17 March 2017

CR2017/000445
SF2012/041993
KAP

PACIFIC HIGHWAY (A1): STATE SIGNIFICANT DEVELOPMENT SSD 7332 – EIS EXHIBITION,
EAGLETON HARD ROCK QUARRY, LOT: 2 DP: 1108702, KILLALOE LANE, EAGLETON

Proposed Italia Rd intersection and Motorplex entrance
Refer Sheet 13 & 14 Fisher Engineering Plans for details

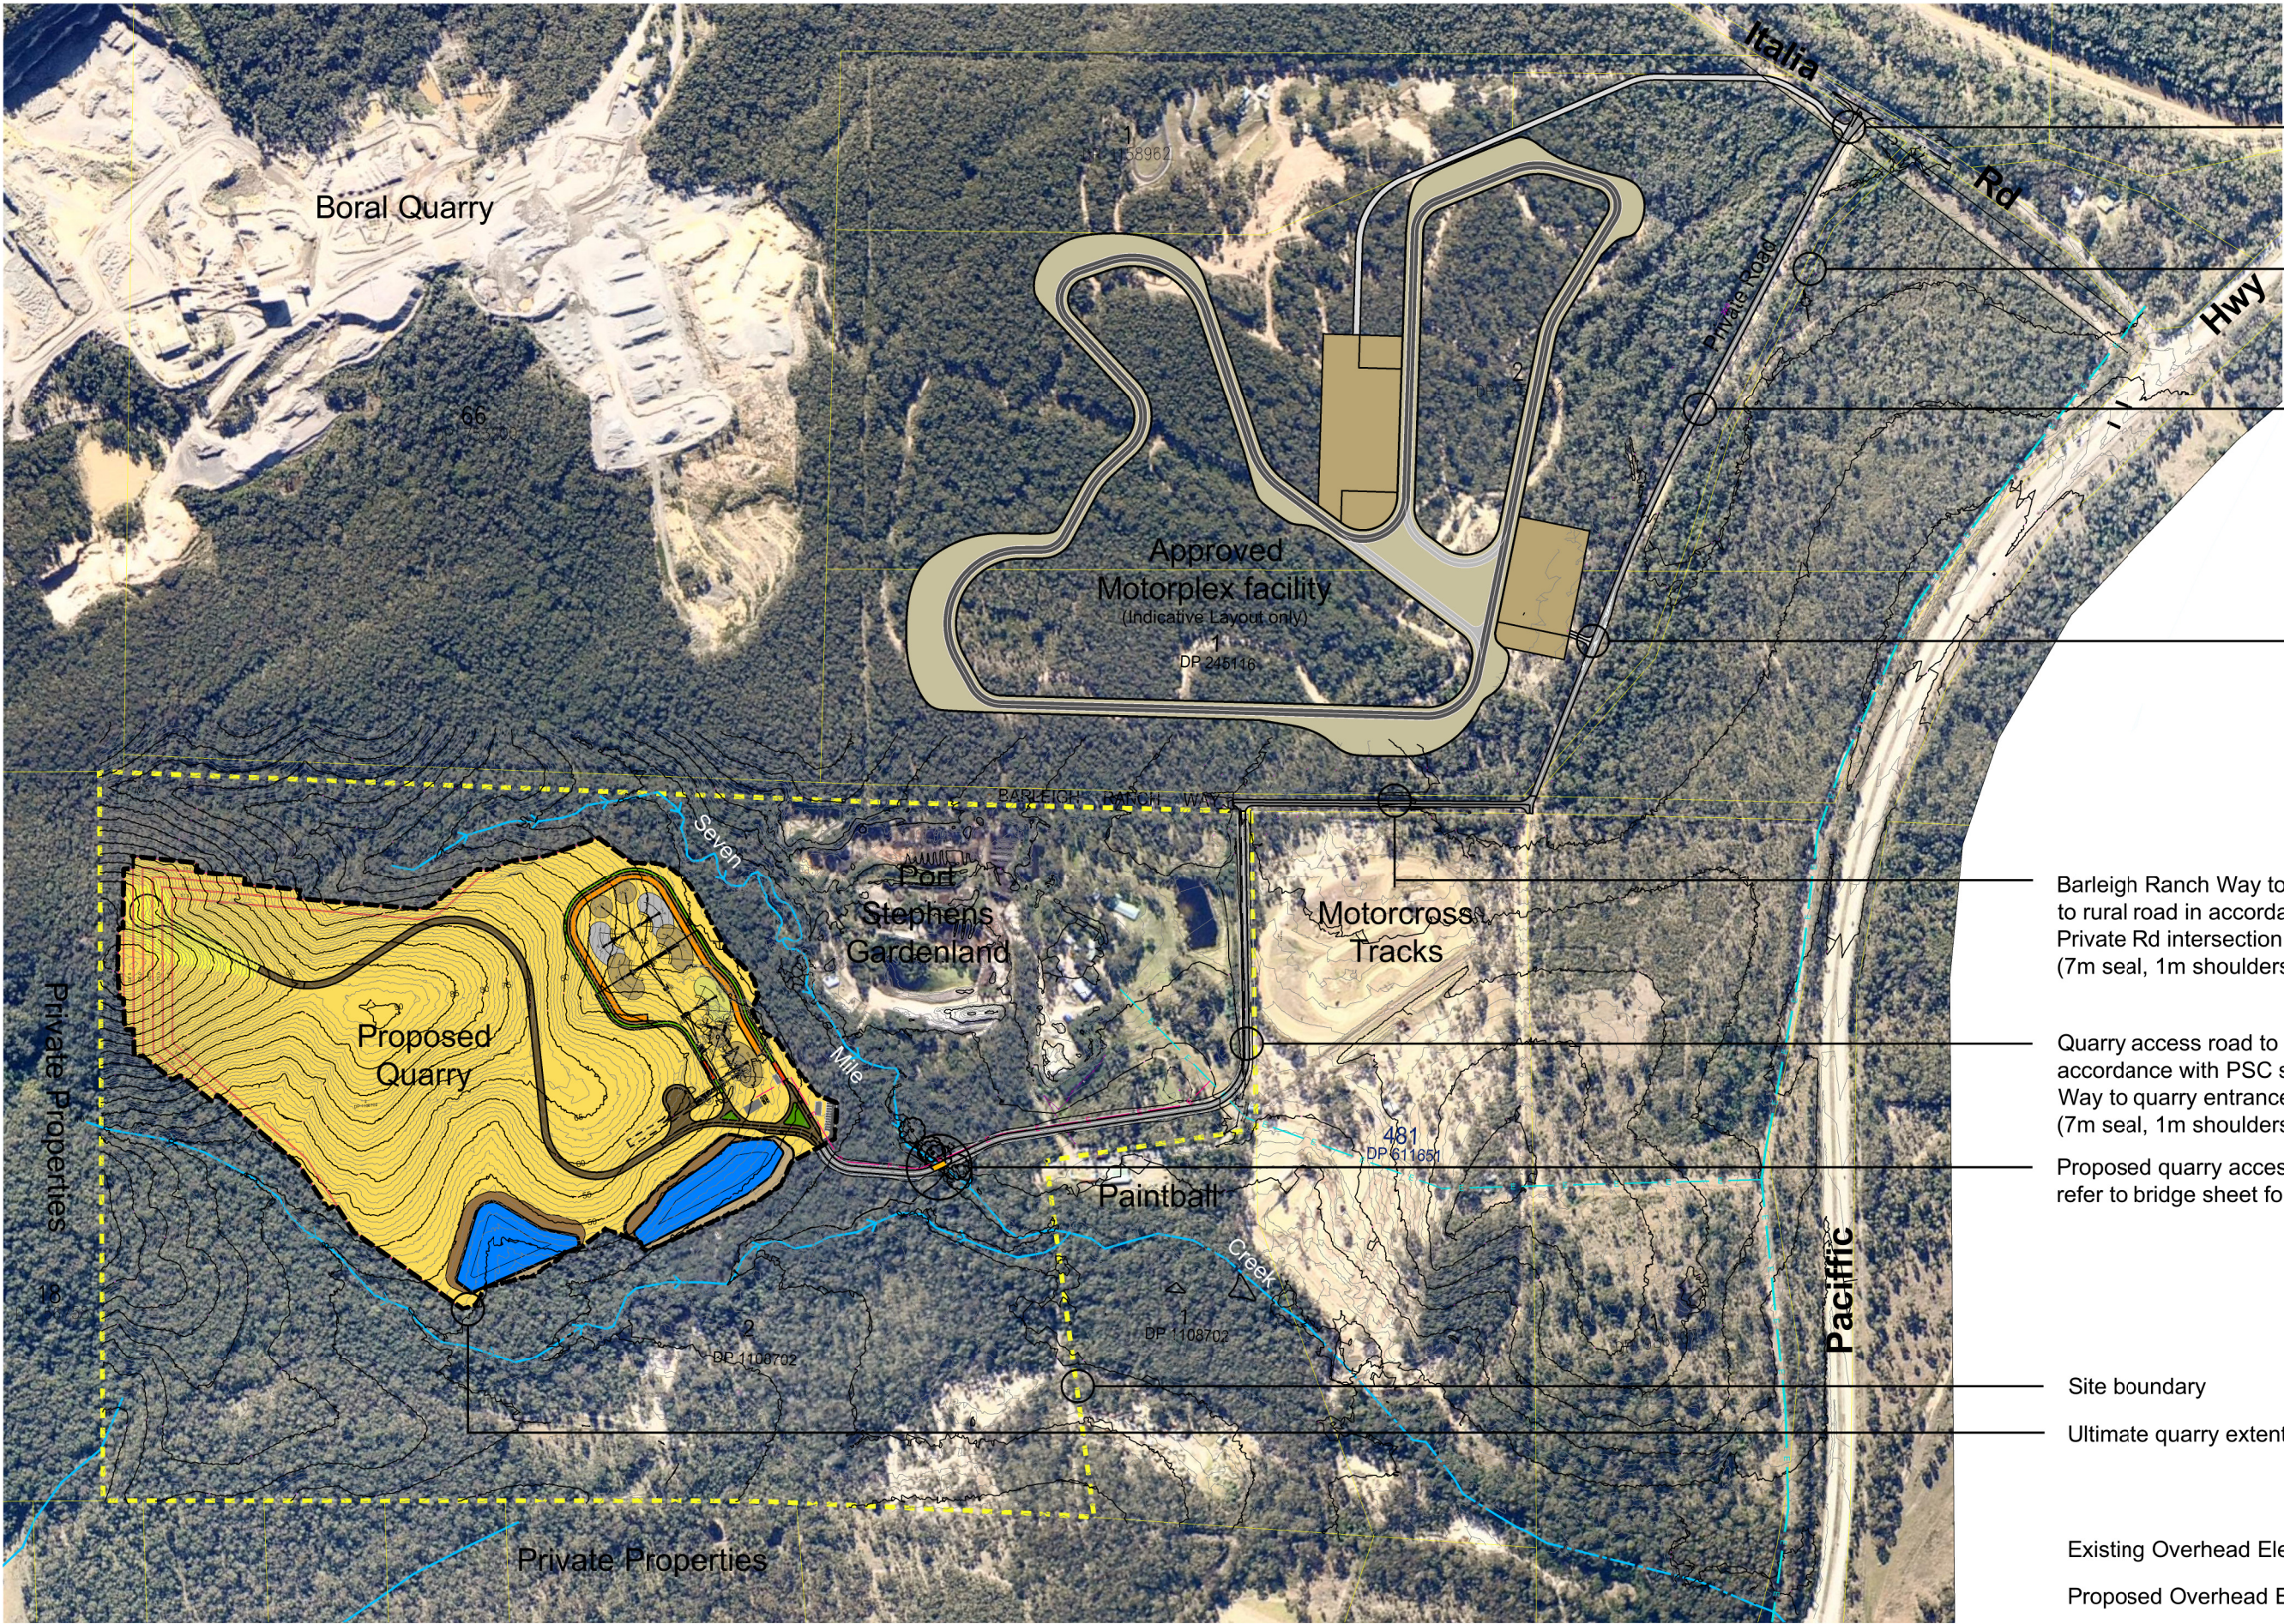
The Road Safety Audit has been submitted with the Traffic Assessment. A review of the audit reveals that there are safety deficiencies in the intersection, specifically the right-turn movement by heavy vehicles, including the slow acceleration times from start to clear northbound carriageway and insufficient acceptable gaps in northbound traffic stream. The proposed increase in heavy vehicle movement generated by the subject development will result in additional demand on the intersection, exacerbating the potential safety risk and the potential crash occurrence and severity.

Roads and Maritime has reviewed the information provided and objects to the proposed development as it is considered the proposal will have an adverse impact on the safety and efficiency of the nearby classified (State) road network, specifically, the intersection of Pacific Highway and Italia Road.

- The proposed gap acceptance used for heavy vehicles is considered to be too short to accommodate a safe movement for the design vehicle. The gap acceptance used within the traffic assessment is based on a light vehicle movement rather than that of the design vehicle, being a heavy laden 25m large truck.

Based on the abovementioned concerns and comments, it is likely that the subject intersection of Pacific Highway and Italia Road will be required to be upgraded to support the proposed quarry operations.
